**State Significant Development Application SSD 7246: Notice of Exhibition for Foreshore
and Public Domain Works at Campbell's Cove, The Rocks**

Thank you for your letter dated 3 February 2017, requesting Transport for NSW (TfNSW) review and comment on the above.

Drawing Title  
**SITE PLAN  
PROPOSED**

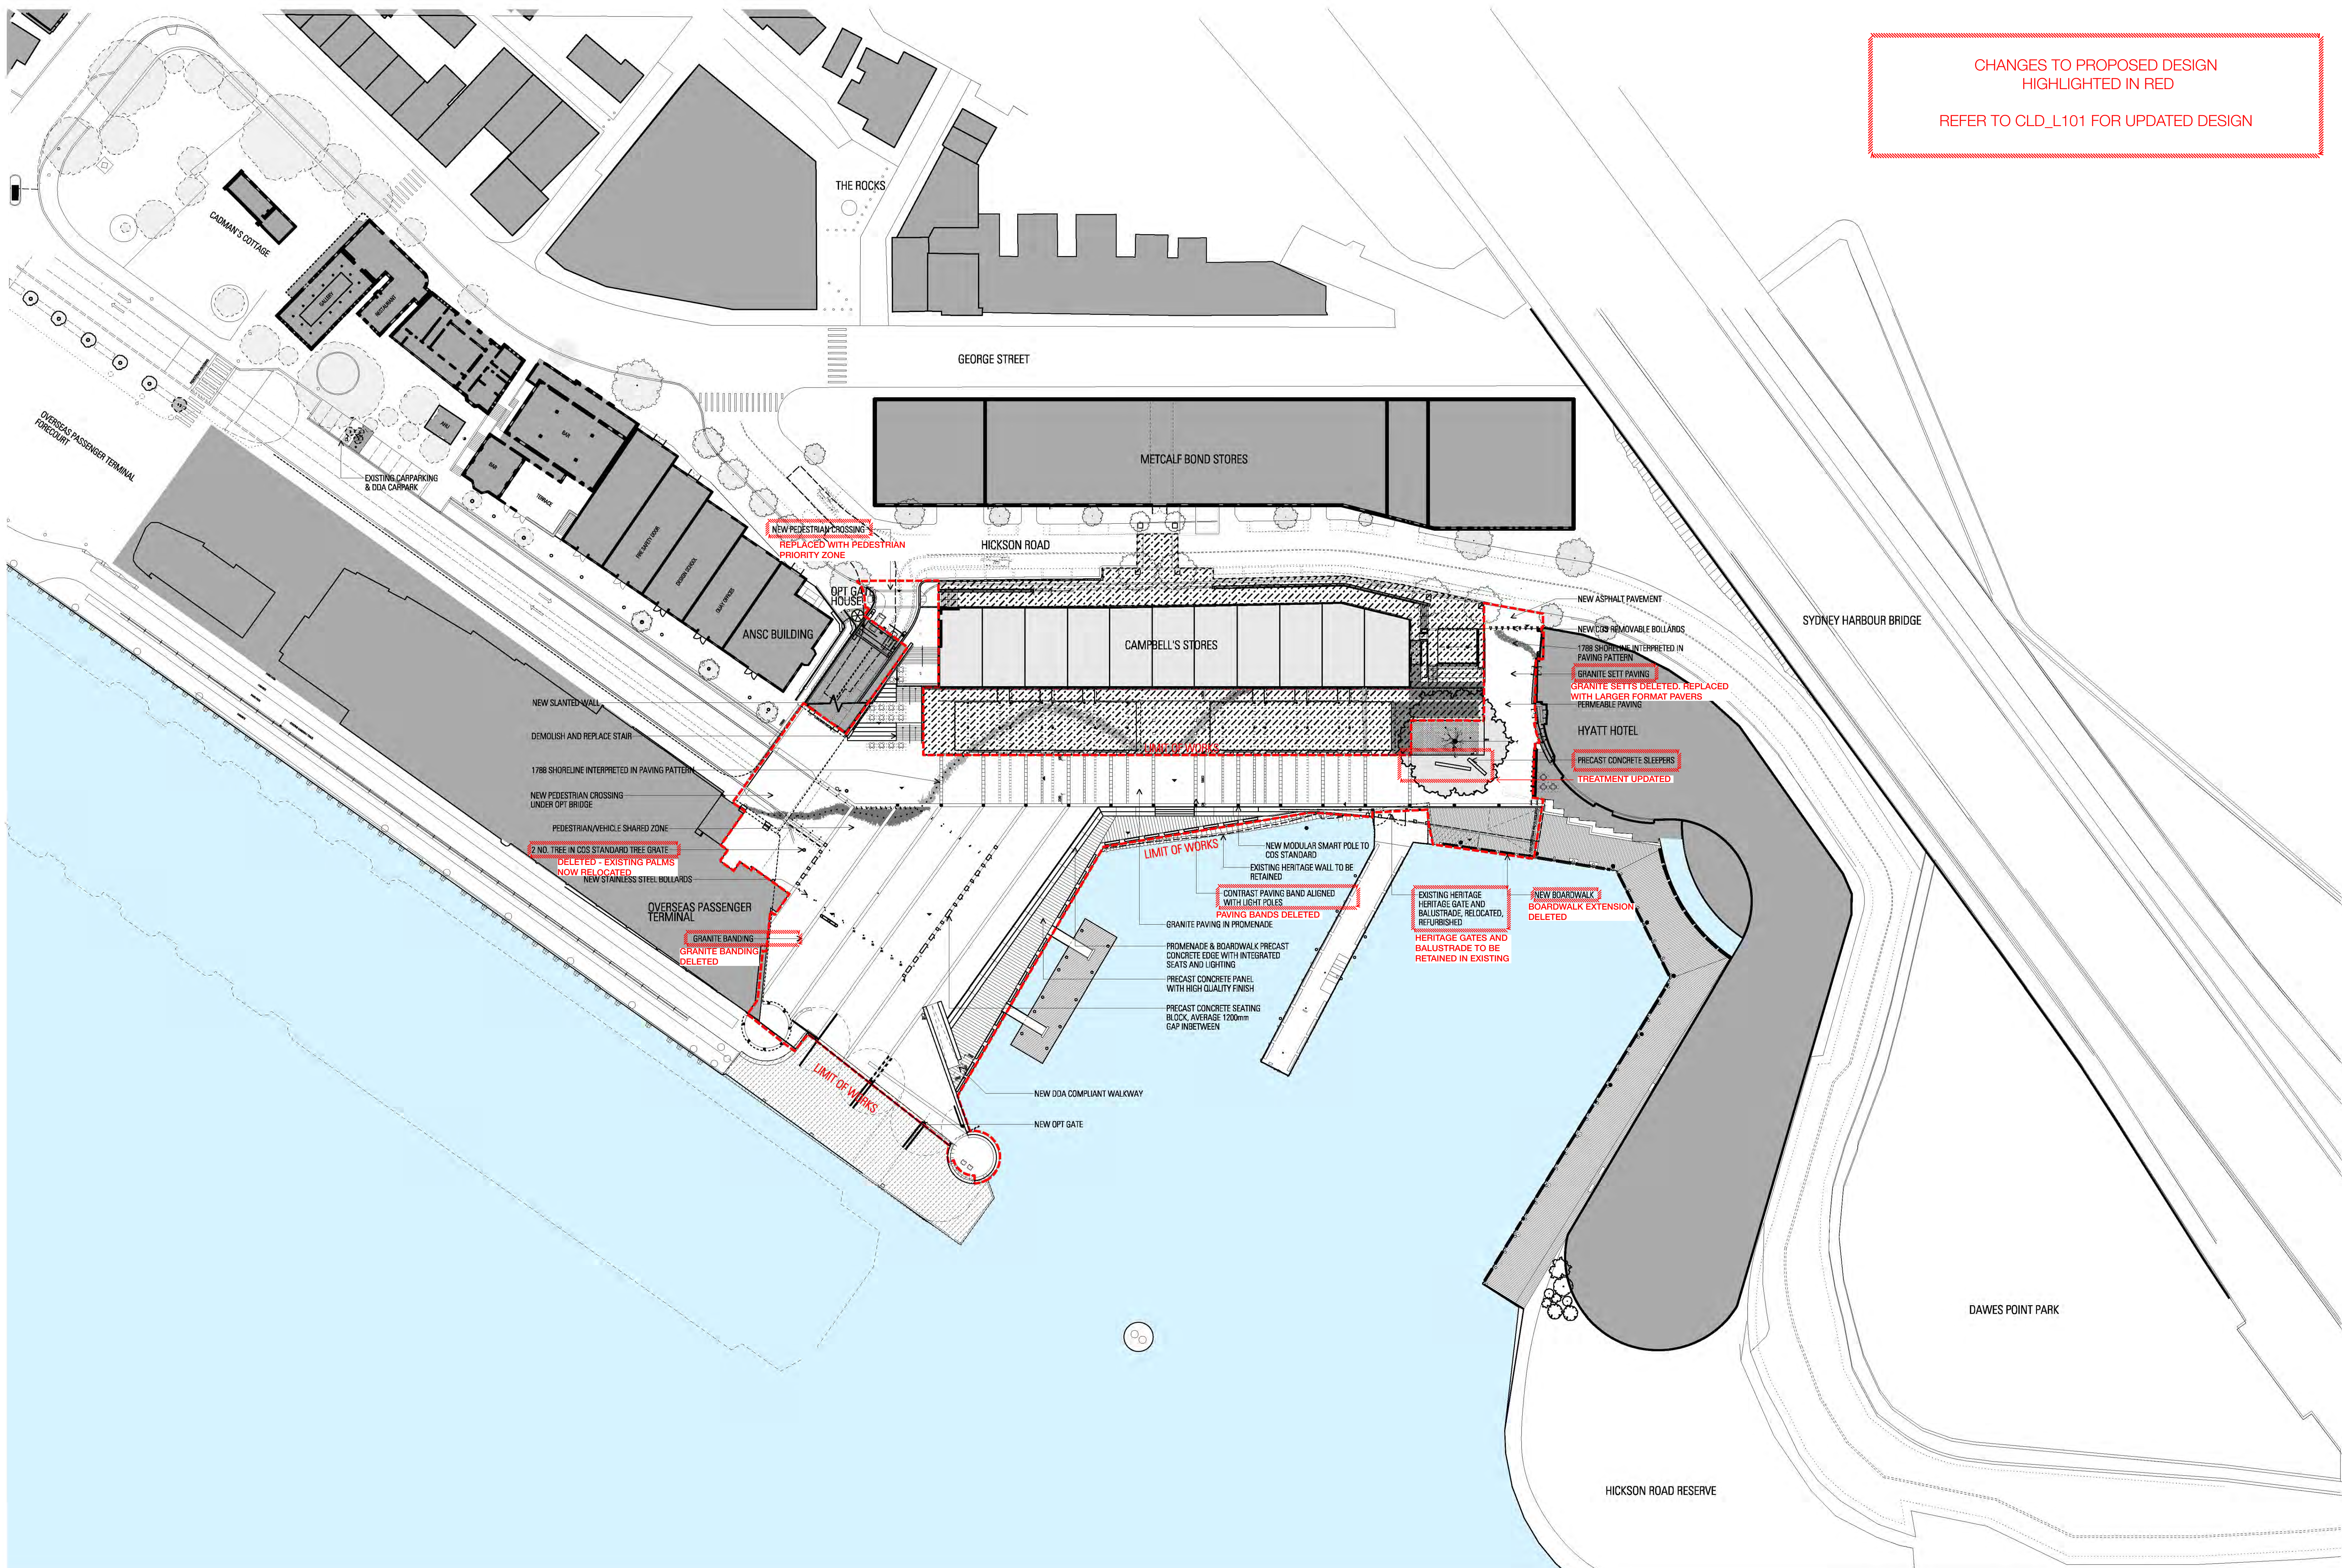
The proposal includes modification of the existing vehicle turning area located at the end of Circular Quay West Road to create a shared plaza/ pedestrian square with removable bollards on the perimeter. The proposed paving arrangement does not show any separation in terms of the colour and texture of the pavers between the vehicle turning path and the surrounding area as shown within the Design Report for the proposal. The proposed arrangement would not alert pedestrians in relation to the potential vehicle movements within the pedestrian square and could have the potential to cause pedestrian and vehicle conflicts.

TfNSW requests that the applicant clearly delineate the vehicle turning path by using pavers of a different colour and texture for the turning path to those around the turning path, similar to the porte cochere of the newly completed International Convention Centre Sydney, including appropriate signage to notify pedestrians of the shared nature of the pedestrian square.
